Town & Country Planning Act 1990 (as amended)
Town & country Planning (Development Management Procedure) (England) Order 2015
Application for Planning Permission for Works or Extension to a Dwelling

Development Single storey rear extension, single storey front/side infill extension & removal of entrance porch at front.

Location 98 Elmer Road Middleton on Sea

Block Plan Amend

No. 14/18/01 X

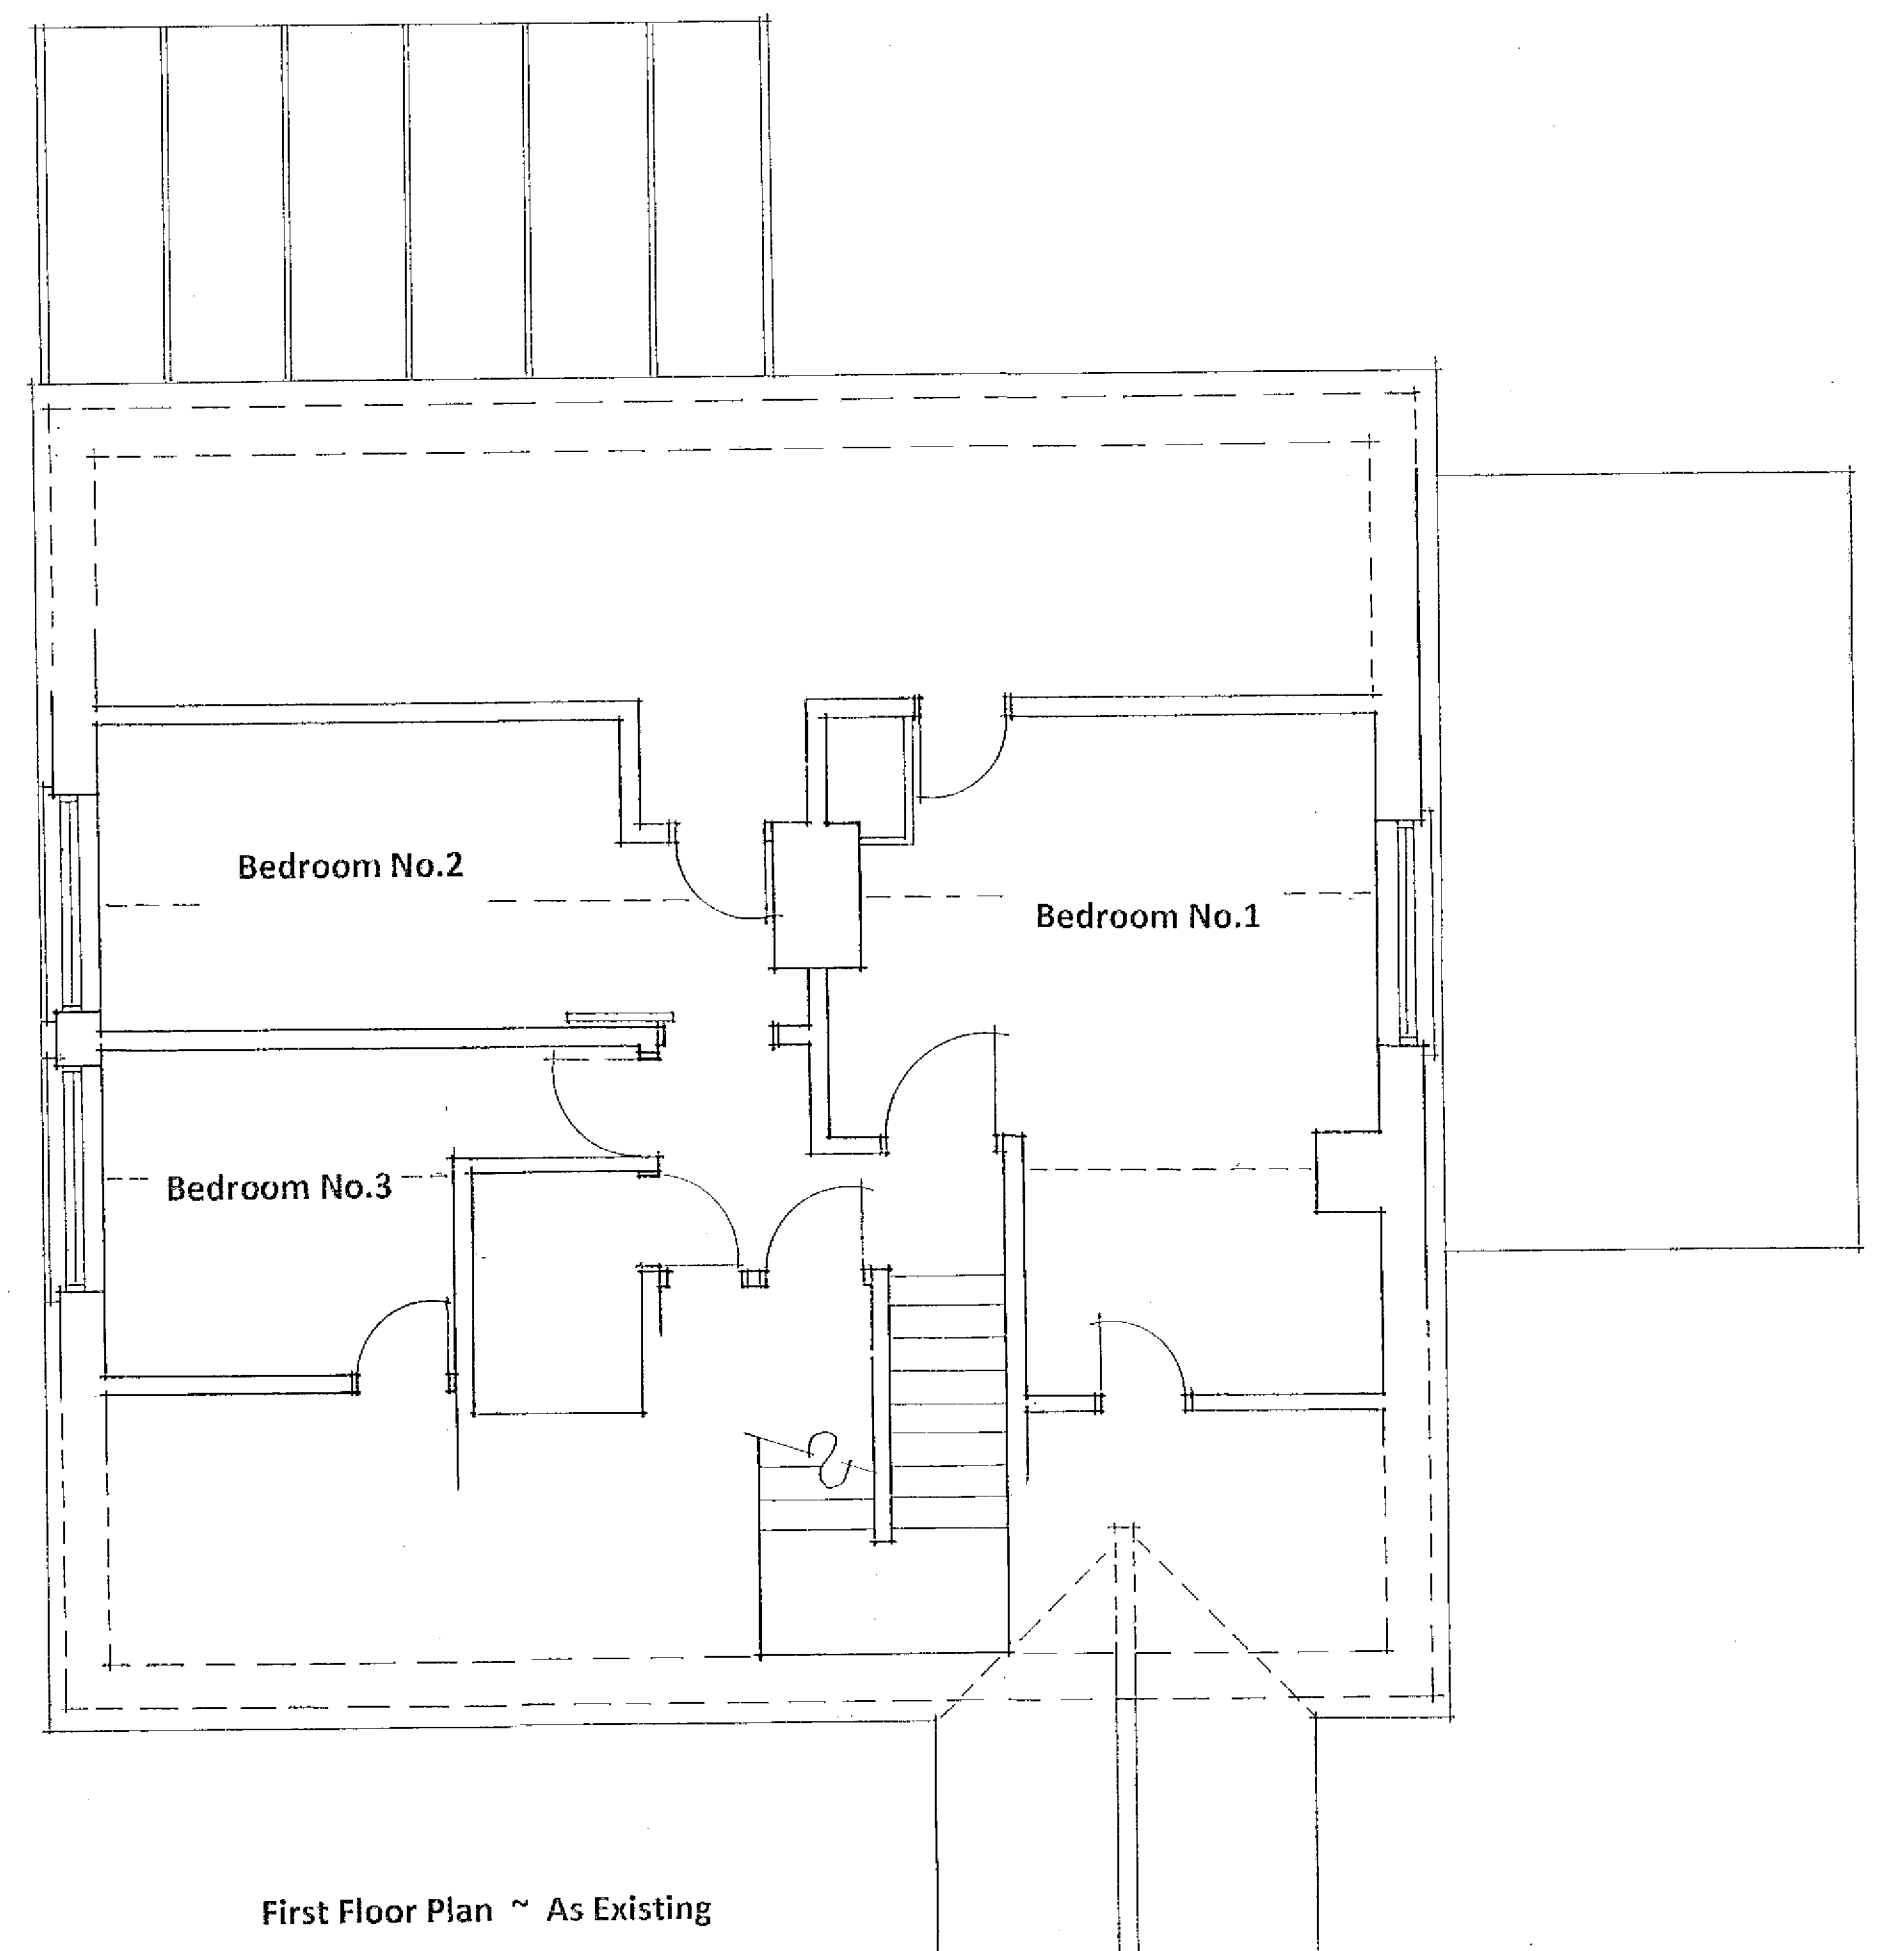
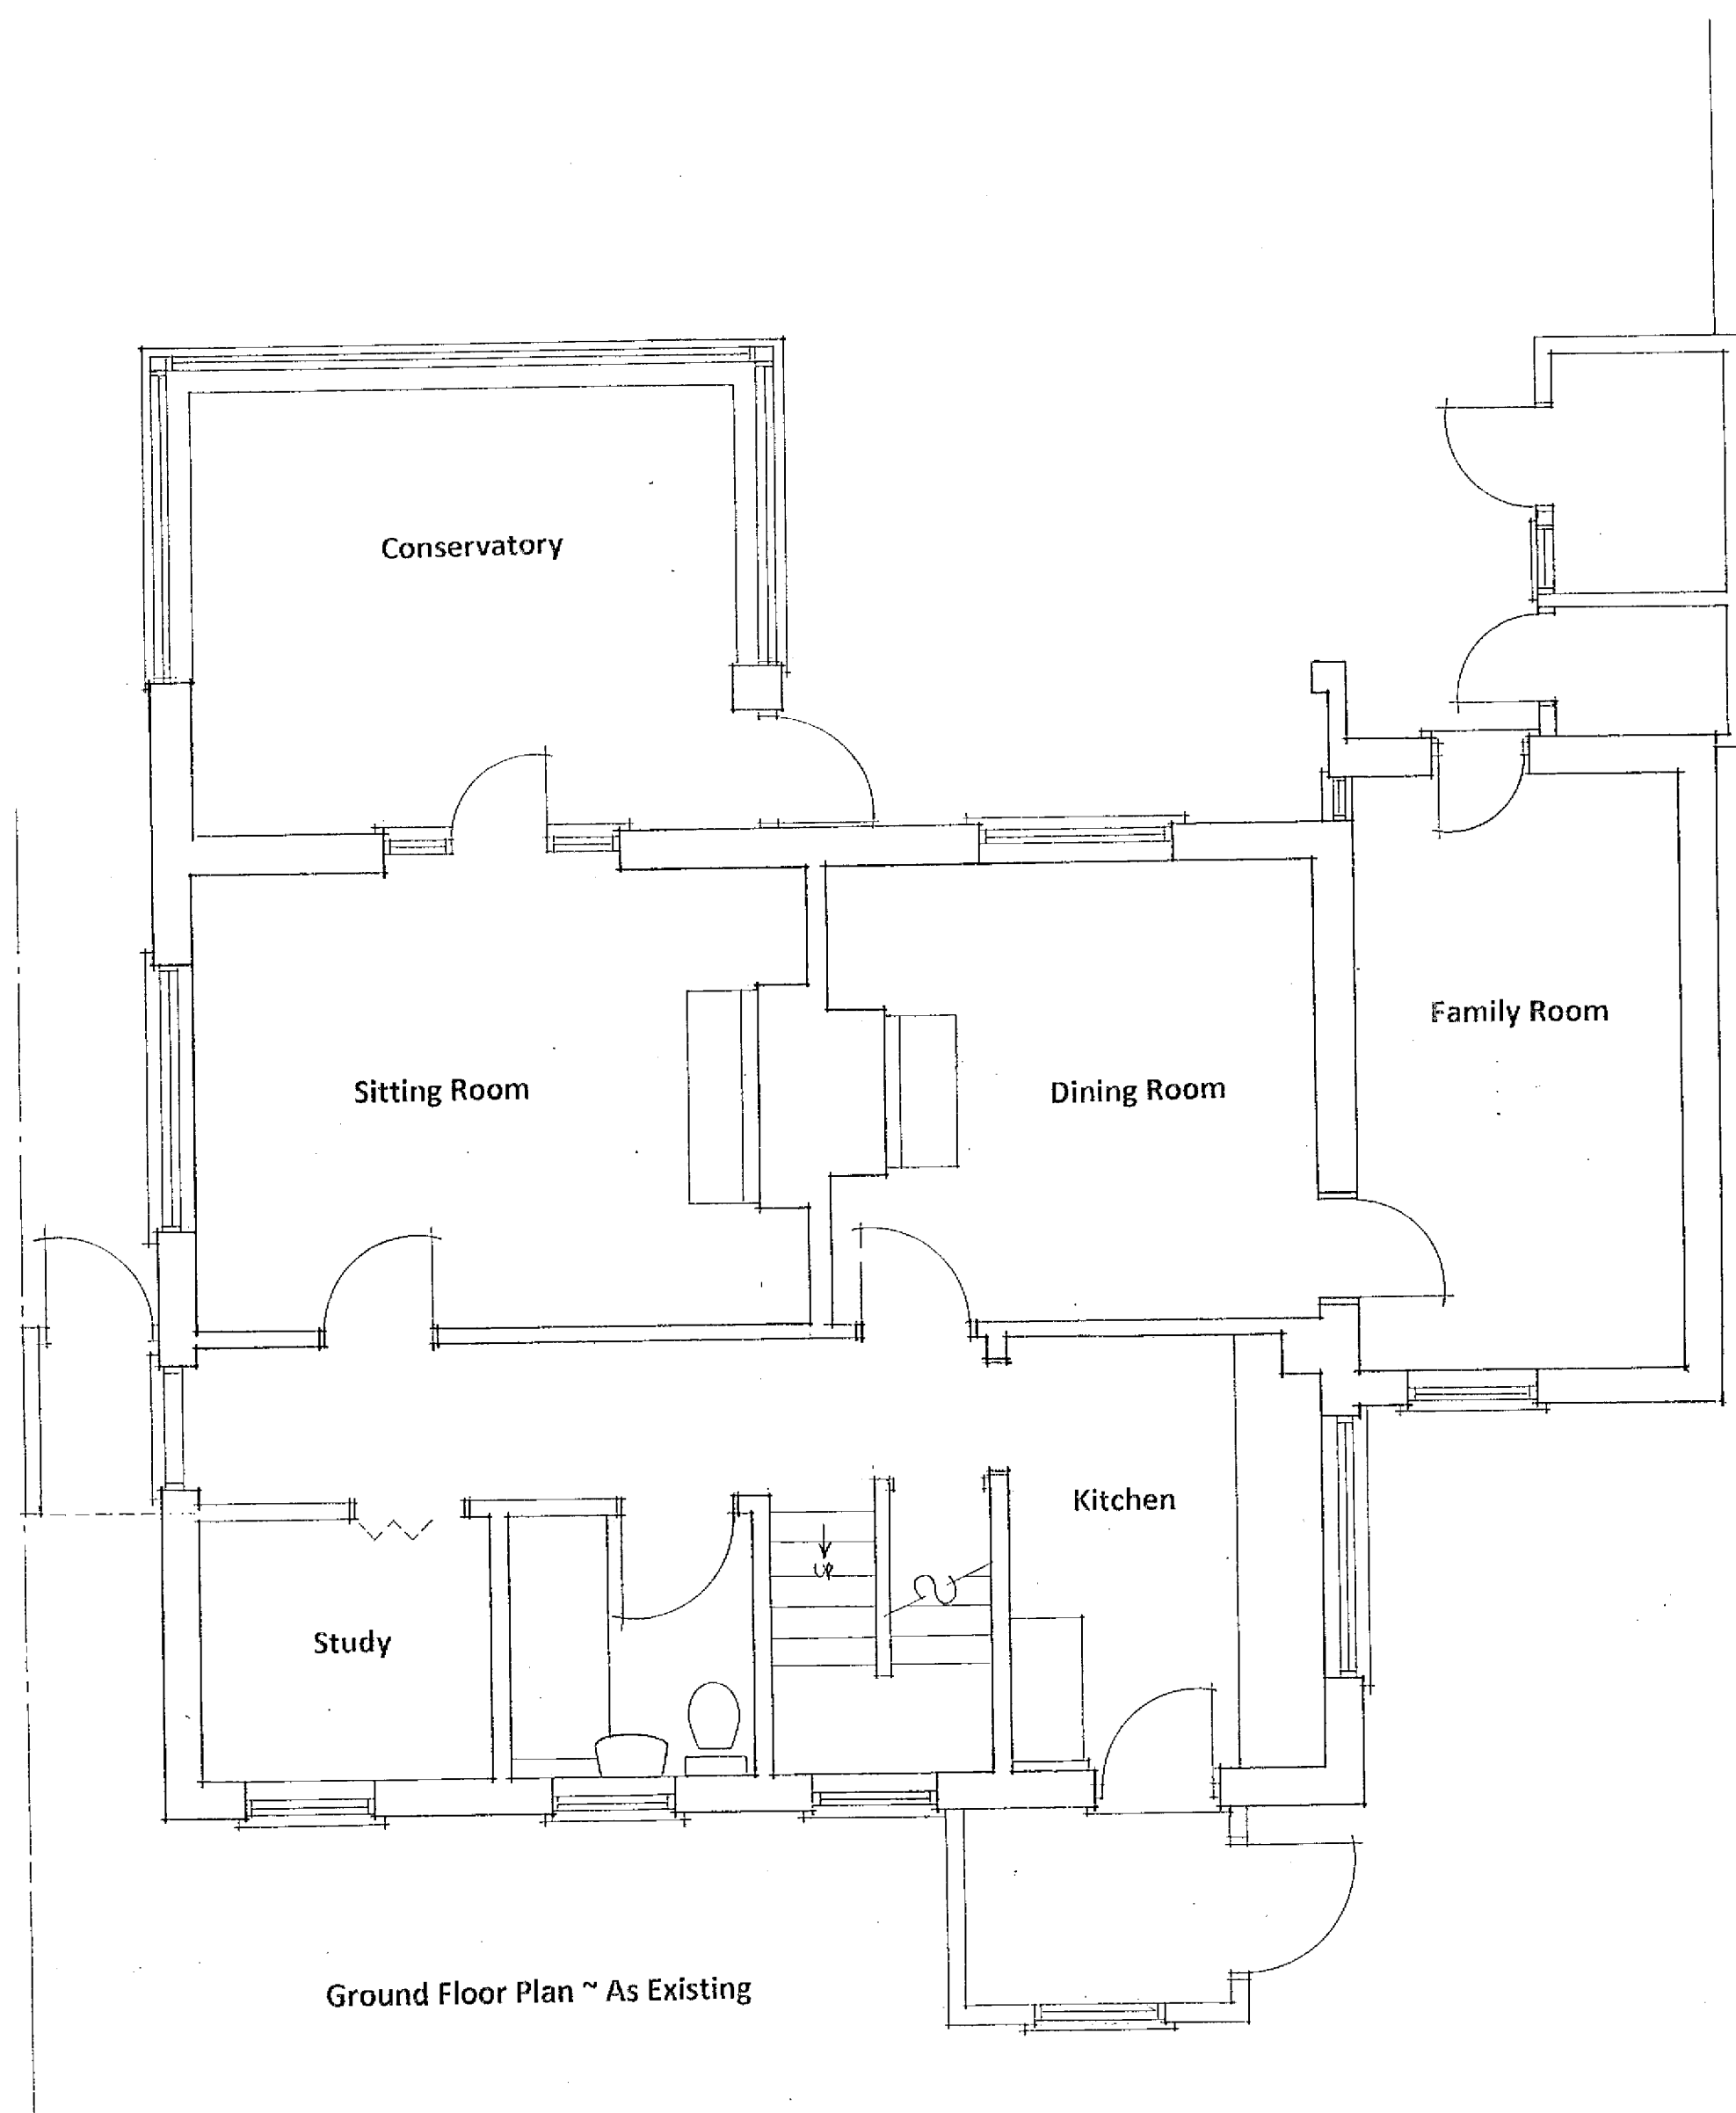
The existing ground floor plan and elevation do not accord. Please amend accordingly.
